14 November 2022

Interim Site Audit Advice No 01, BE167, Royal Prince Alfred Hospital, Remediation Action Plan review

- Cardno, 2022j. Remediation Action Plan, Royal Prince Alfred Hospital. Cardno Ref: 80022026_R004_RPA East Campus_RAP_Rev0.docx. 10 November.

EXTENT OF WORKS DIAGRAM

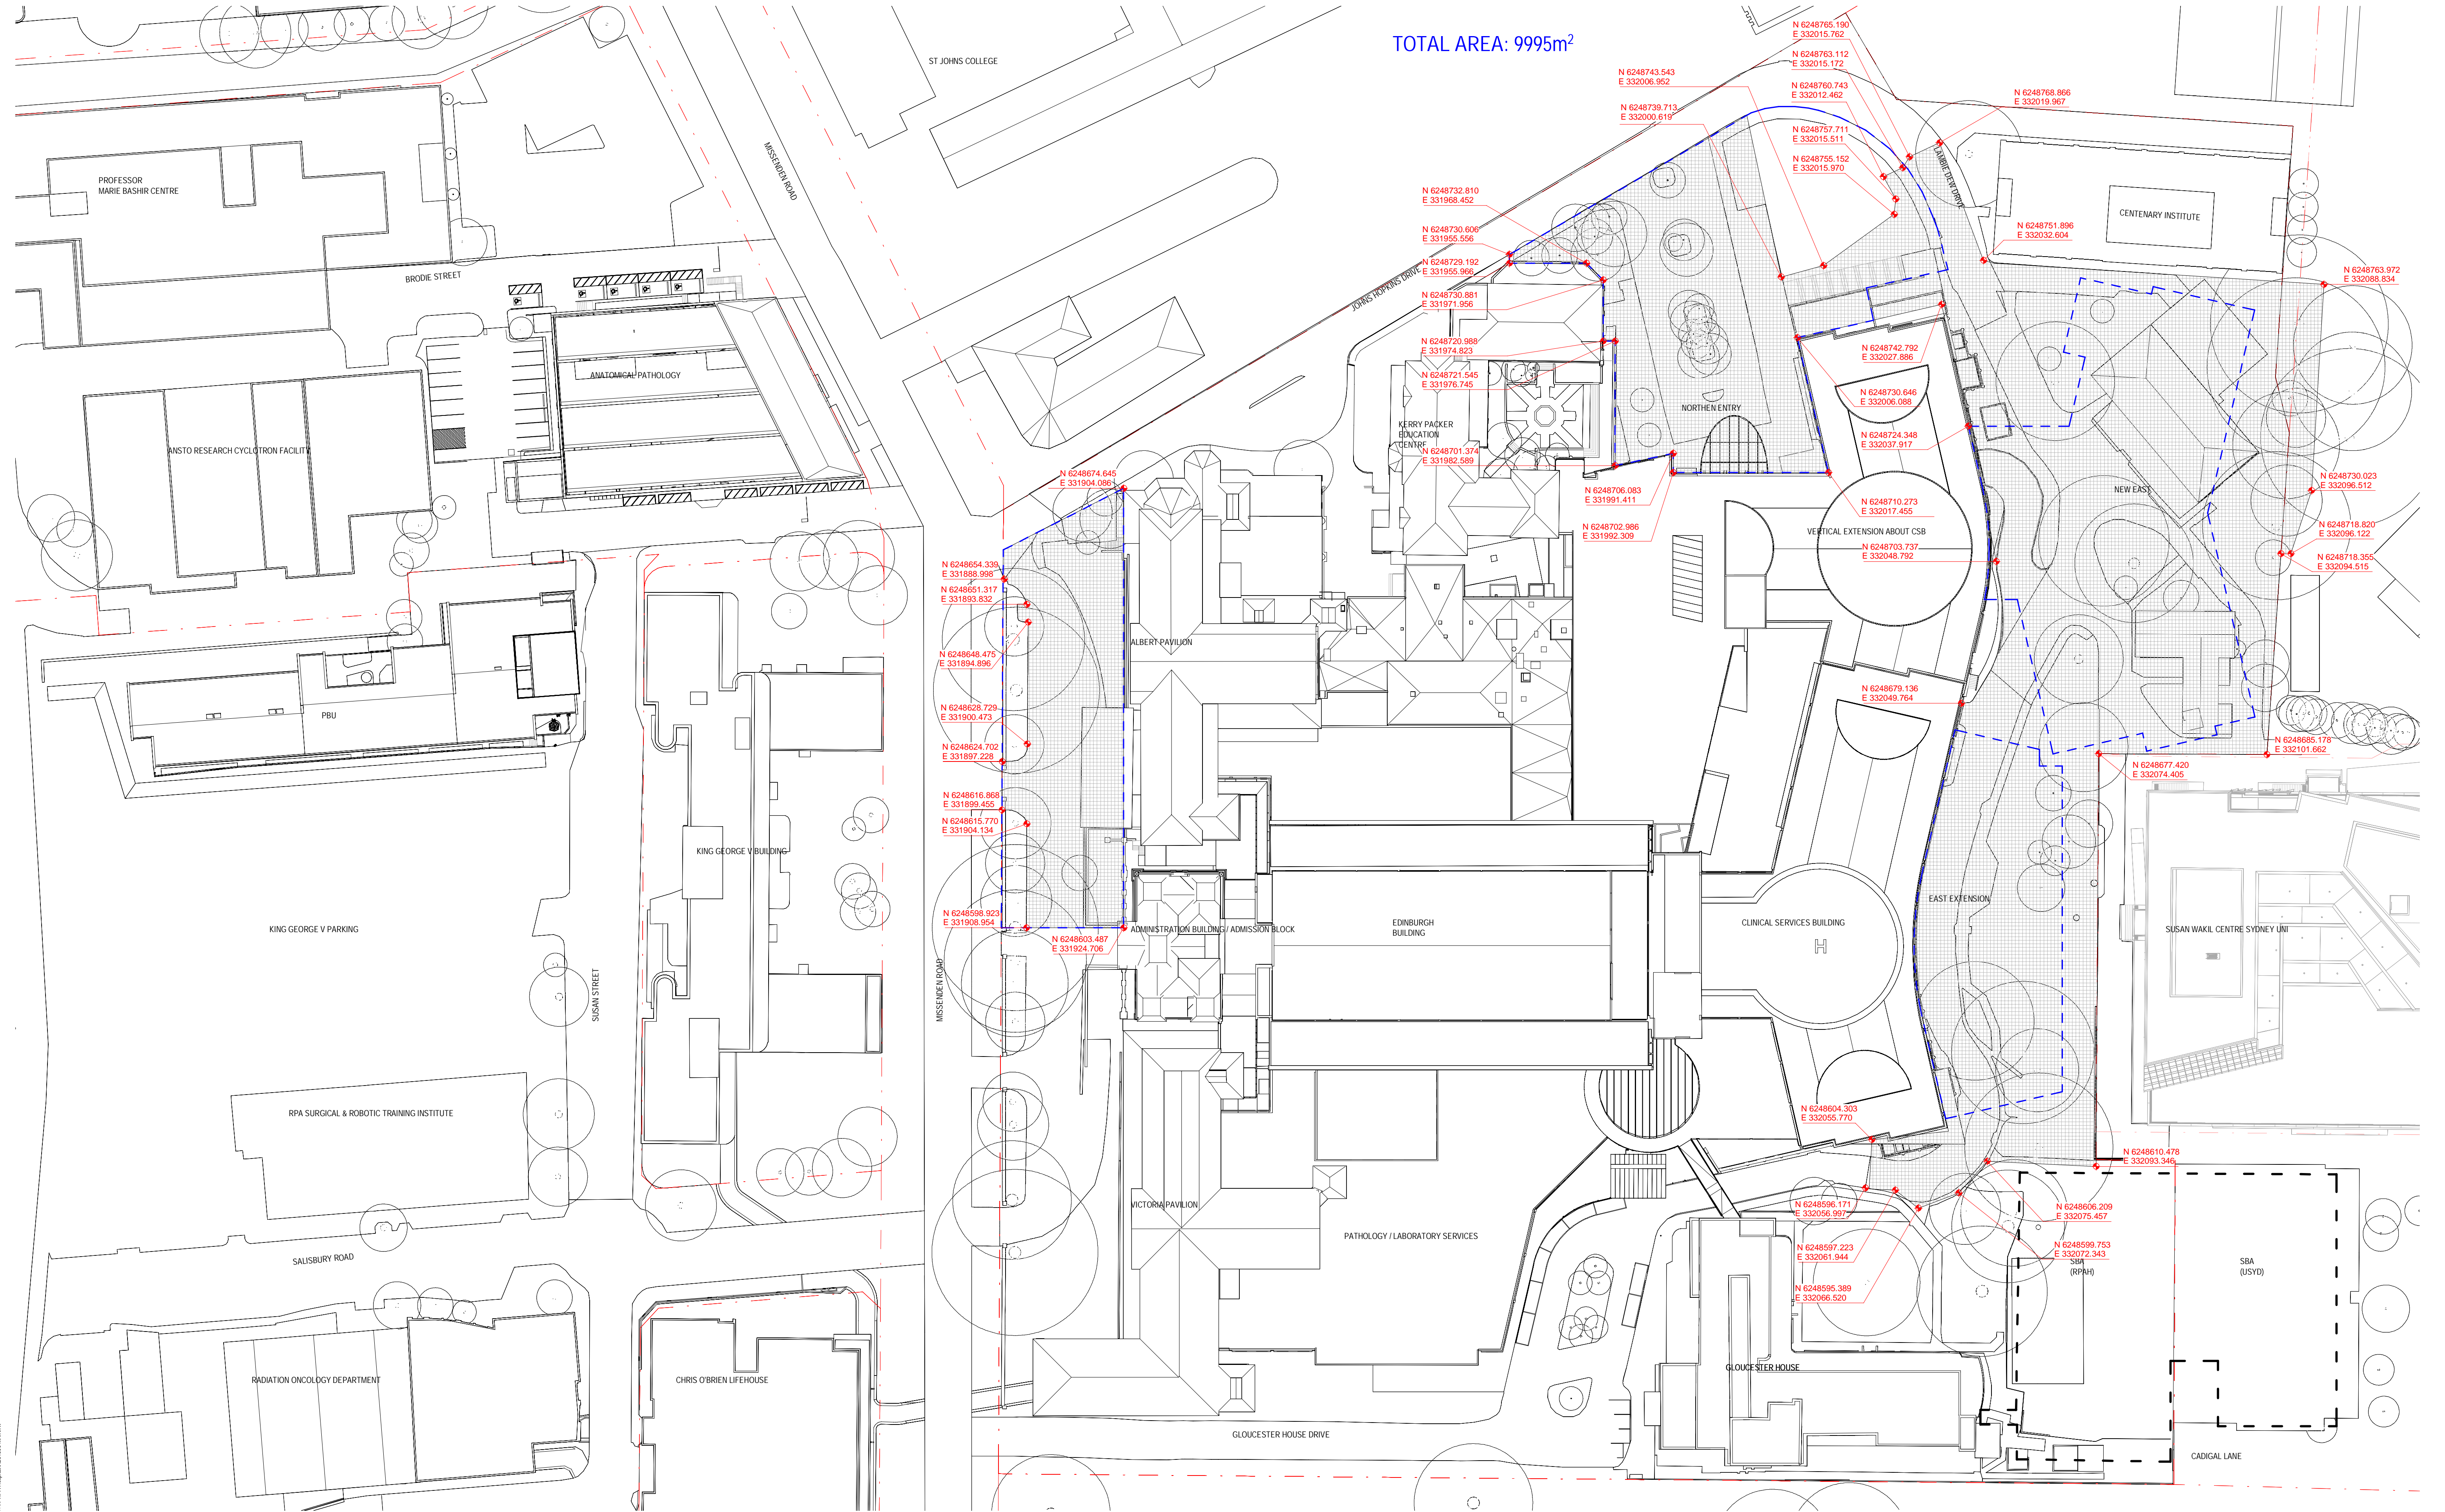
- The total area described in Drawing 11/02/22_ IA0251300- SK-SK-2001 Extent of Works Diagram included in the Cardno (2022i) DSI indicated the total area to be 9,995m². The site identification table in the DSI indicated the total area to be 9,320m² (1,205+155+6,748+1,212) when the areas are added (see Table 2 below). The Auditor considers that these discrepancies should be addressed by providing a survey plan of final the remediated area in the validation report.
